Your reference: SSD-71547218

Development Application

**State Significant Development – EIS & DA Exhibition – Waste or resource management facility
8 Styles Street Kurri Kurri NSW 2327, 1//DP1309128**

The RFS has reviewed the bush fire hazard assessment, undertaken in the bush fire report prepared by Cool Burn Pty Ltd (Version 1.1 and dated 12 February 2025) to demonstrate compliance of the proposed works with relevant provisions of Planning for Bush Fire Protection (PBP) 2019.

Weighbridge Shed - 1st / 2nd Floor Plan  
Scale: 1 : 100

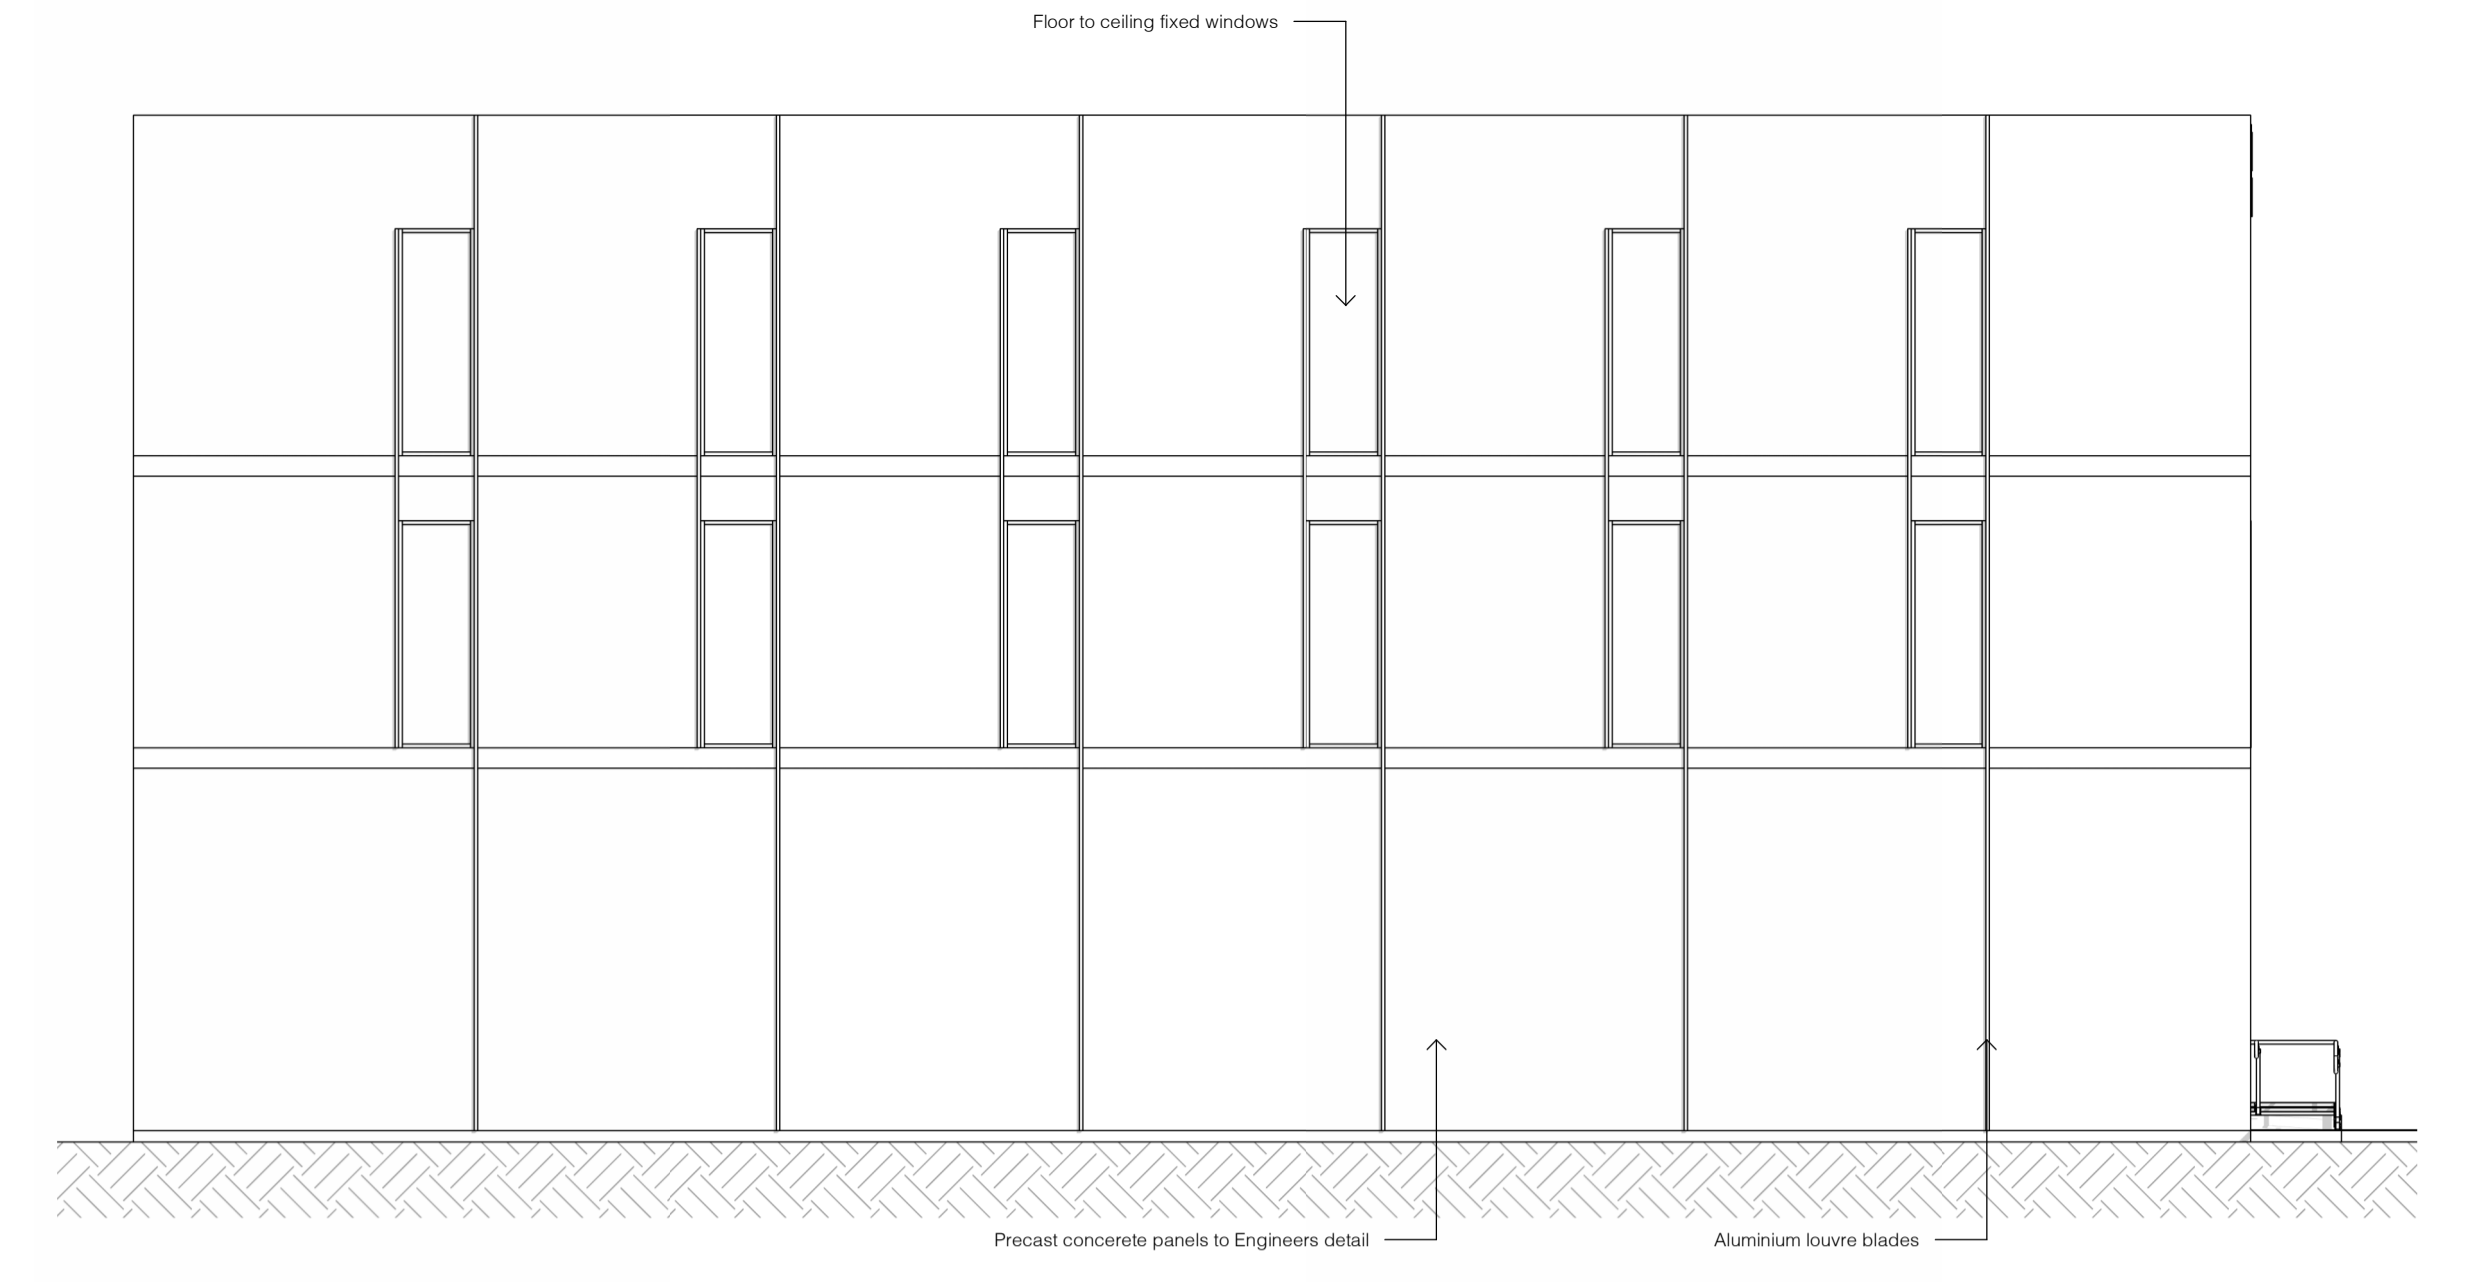
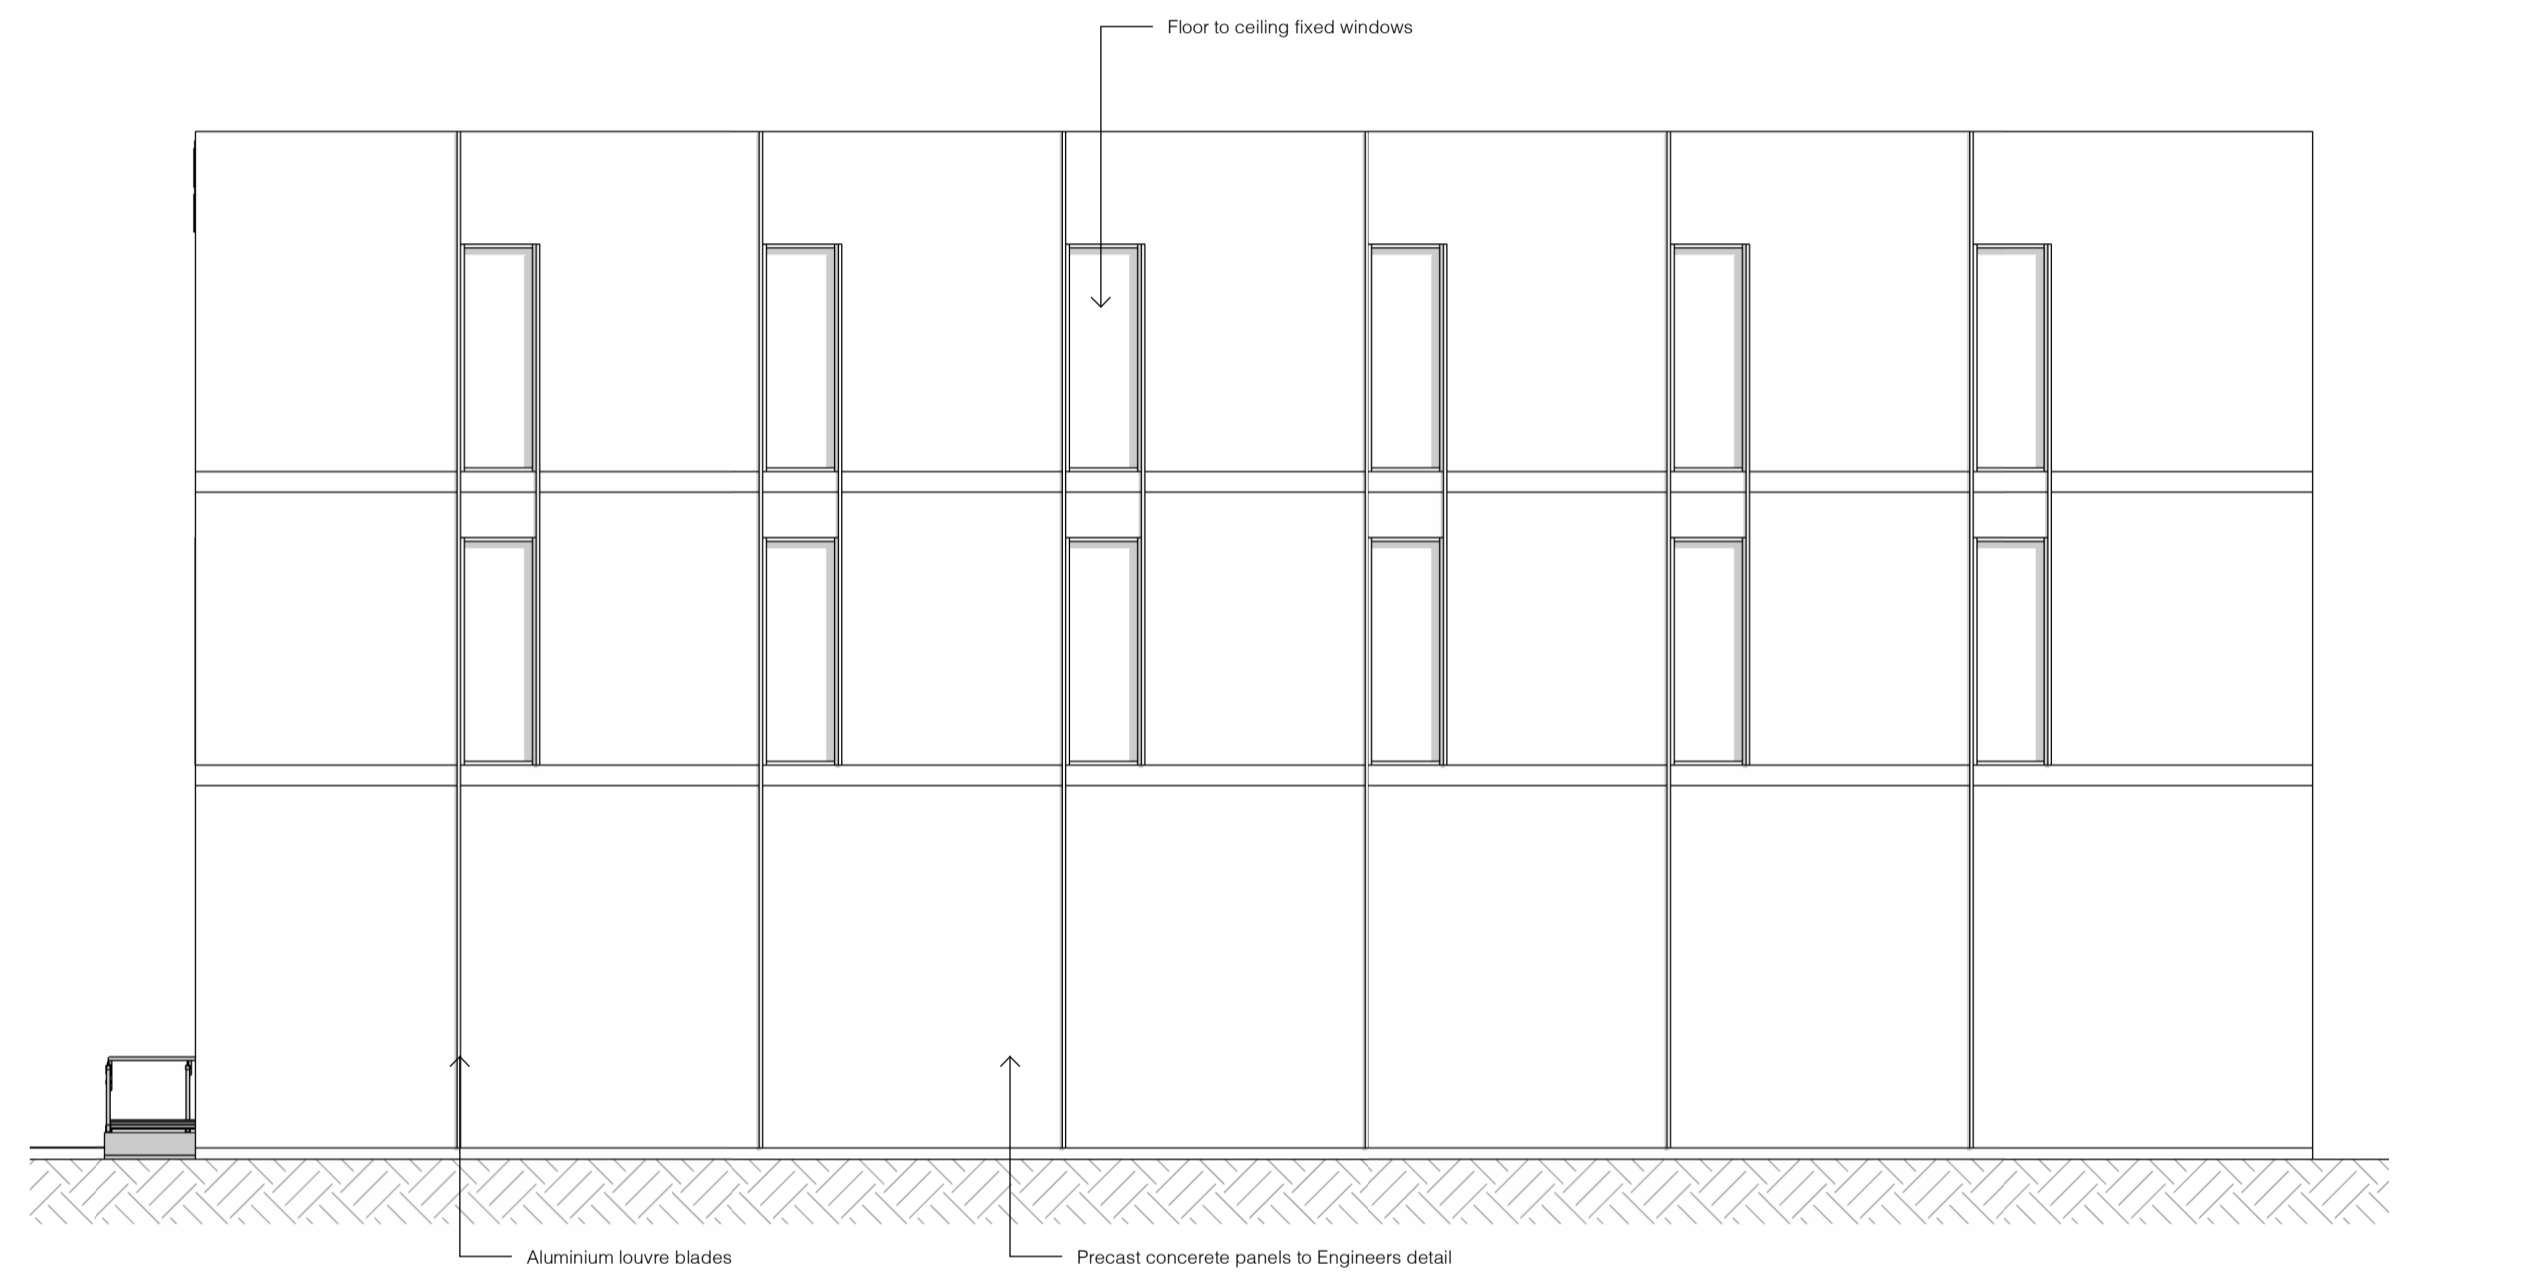
5. The proposed offices located above the weighbridge, must be upgraded to improve ember protection by enclosing all openings (excluding roof tile spaces) or covering openings with a non-corrosive metal screen mesh with a maximum aperture of 2mm. Where applicable, this includes any sub floor areas, openable windows, vents, weepholes and eaves. External doors are to be fitted with draft excluders.
